WEST SUSSEX COUNTY COUNCIL CONSULTATION

TO:	Arun District Council FAO: S Davis
FROM:	Highways, WSCC
DATE:	13 th November 2018
LOCATION:	Land West of, Fontwell Avenue, Eastergate, PO20 3RU
SUBJECT:	AL/117/18/PL Variation of conditions 2, 6, 7 & 8 imposed under AL/122/17/PL relating to the substitution of plan BP/LP RevC with SP01 RevB (proposed site plan).
RECOMMENDATION:	☐ Advice ☐ Objection ☐ Modification ☐ No Objection ☒ More Information ☐ Refusal
S106 CONTRIBUTION TOTAL:	£N/A

TITLE
PROPOSED
SITE PLAN

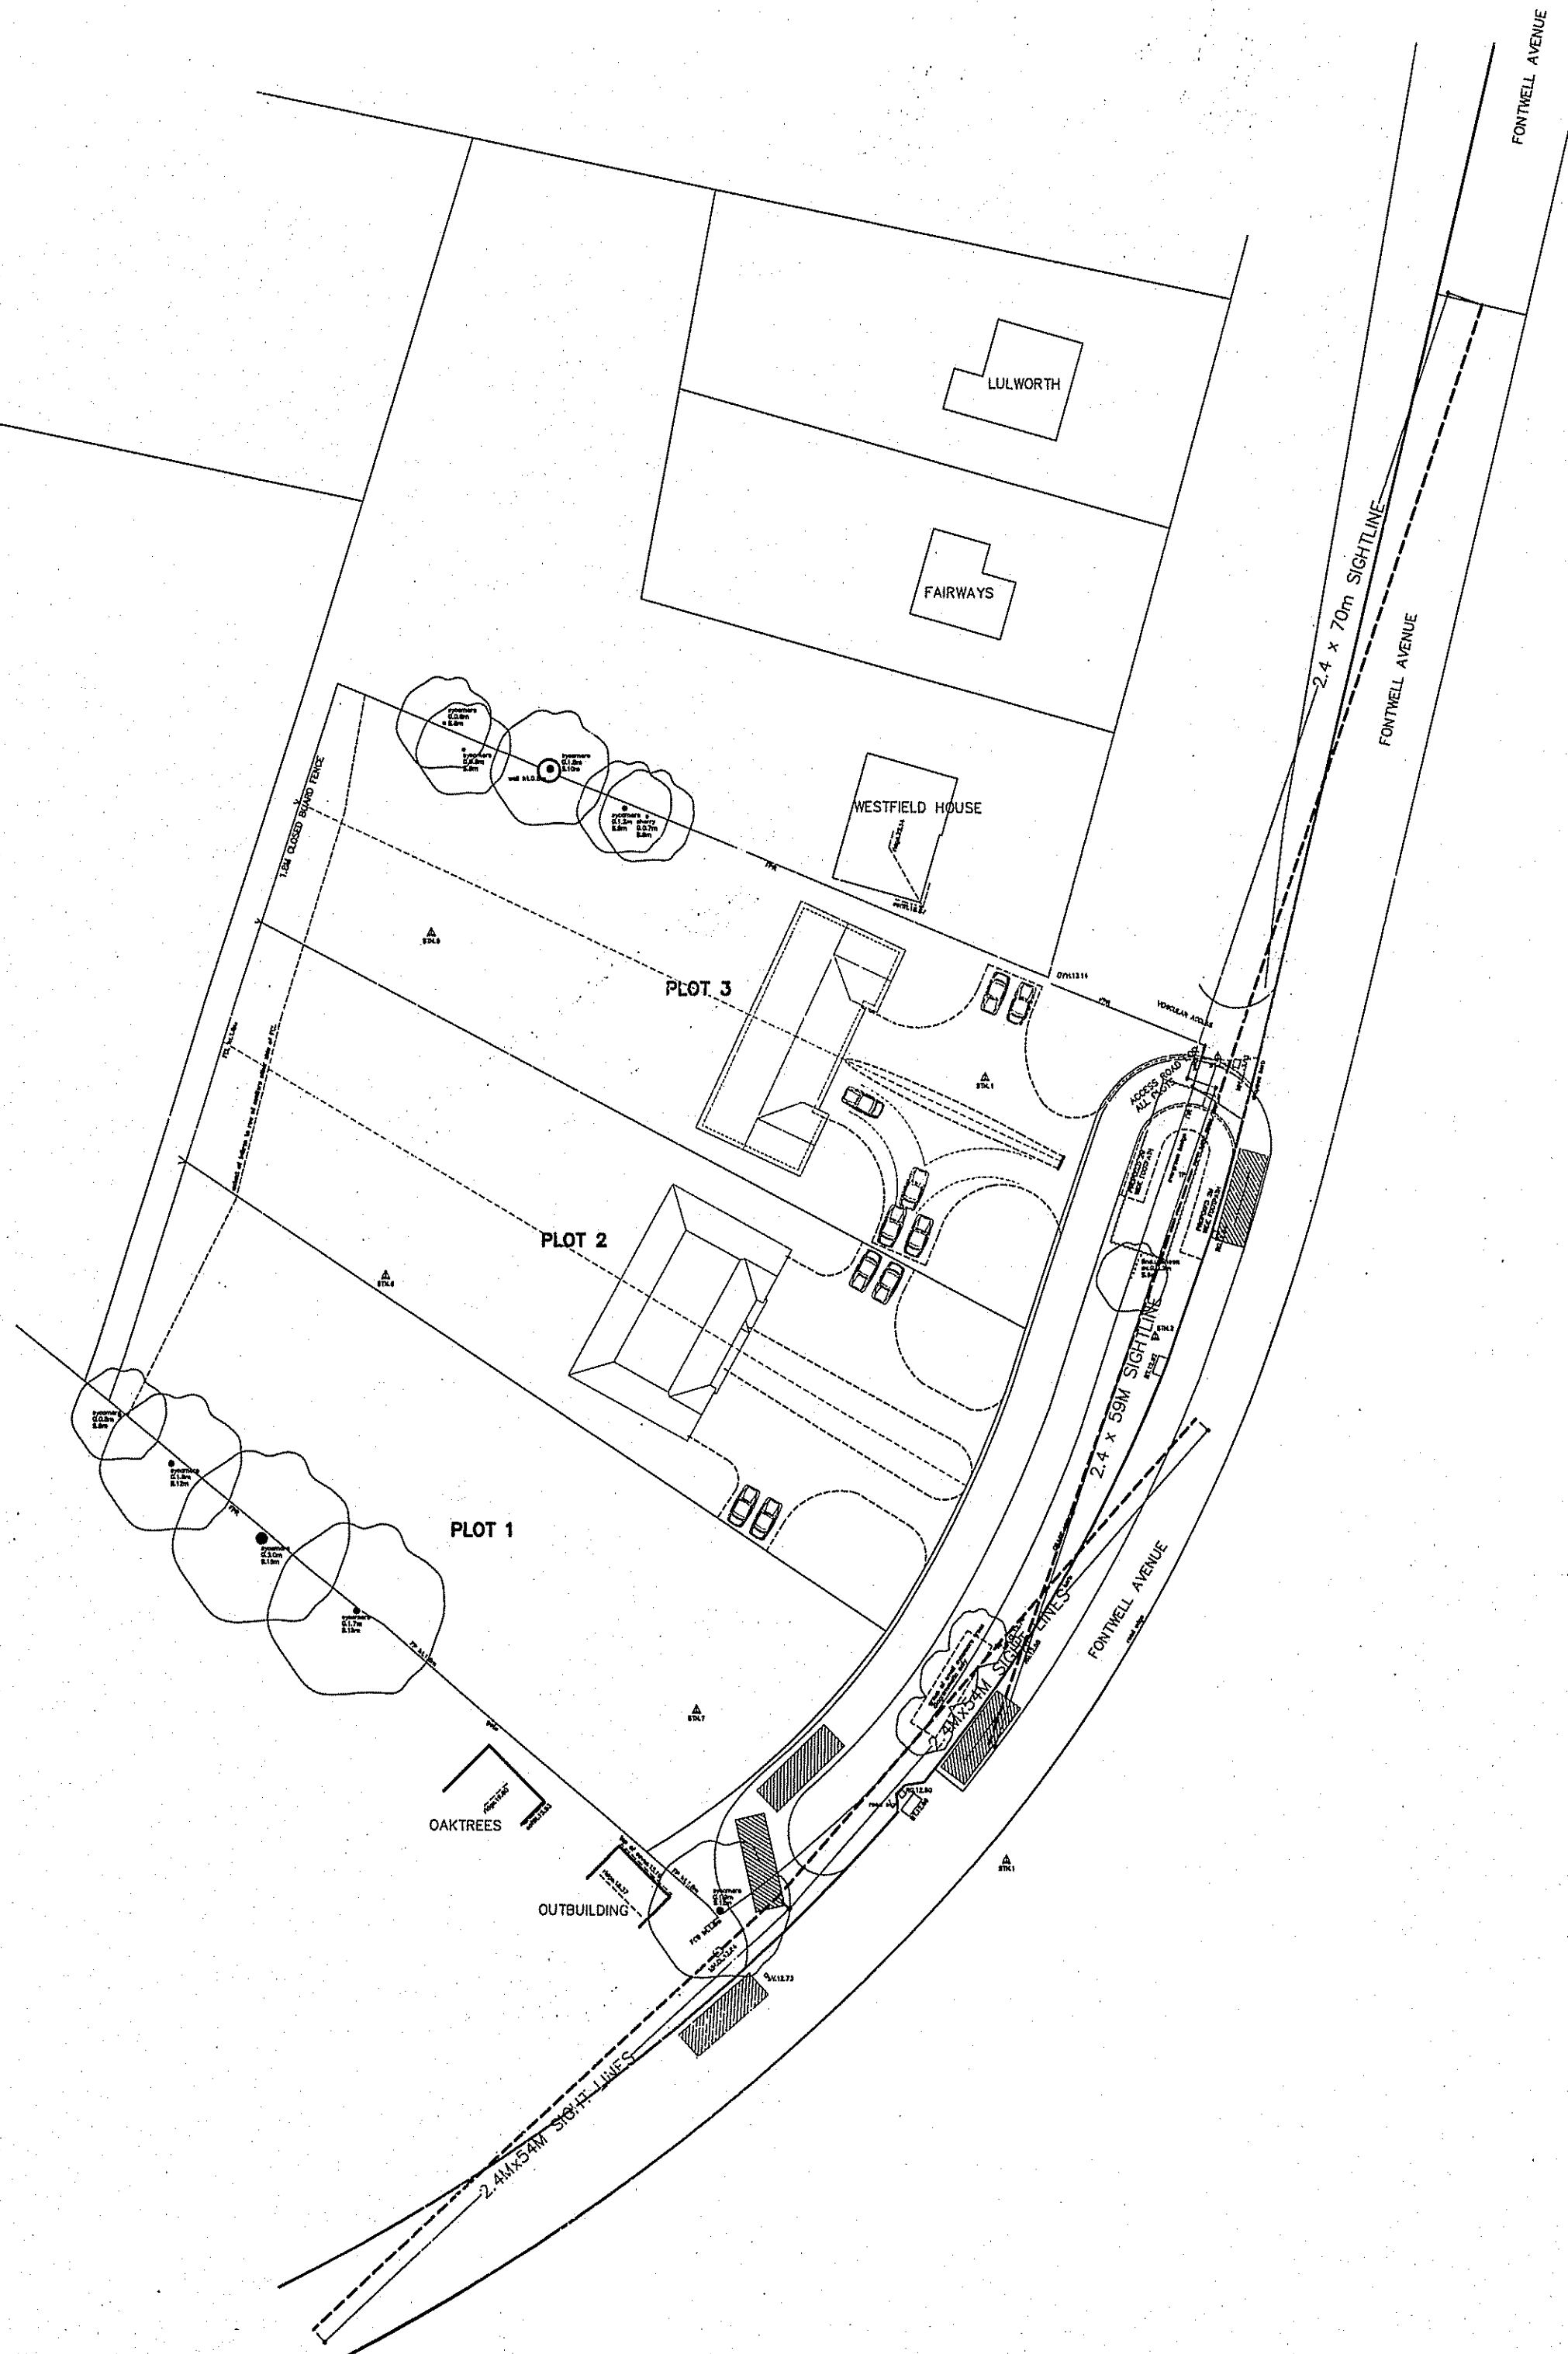
Under AL/136/17 vehicular visibility splays of 2.4m by 59m were provided from the centre of the proposed southern access, extending to the nearside carriageway edge. As per previous comments these splays were considered suitable and in line with recorded vehicle speeds. Splays of 2.4m by 54m to the centre line in either direction have been provided on the amended site plan. This is not in line with the access approved under AL/136/17. Splays of 2.4m by 59m should be demonstrated from both access points and in both the north and south directions; these should not pass through third party land and should extend to the nearside carriageway edge.

The previously approved footway link and pedestrian crossing (tactile paving) points have also not been satisfactorily demonstrated on the revised site plan.

Please ask the applicant to amend the plan ensuring that visibility splays, within the red edge of the site and publically maintained highway, are accurately plotted as per comments above and that the approved footway link is also represented.
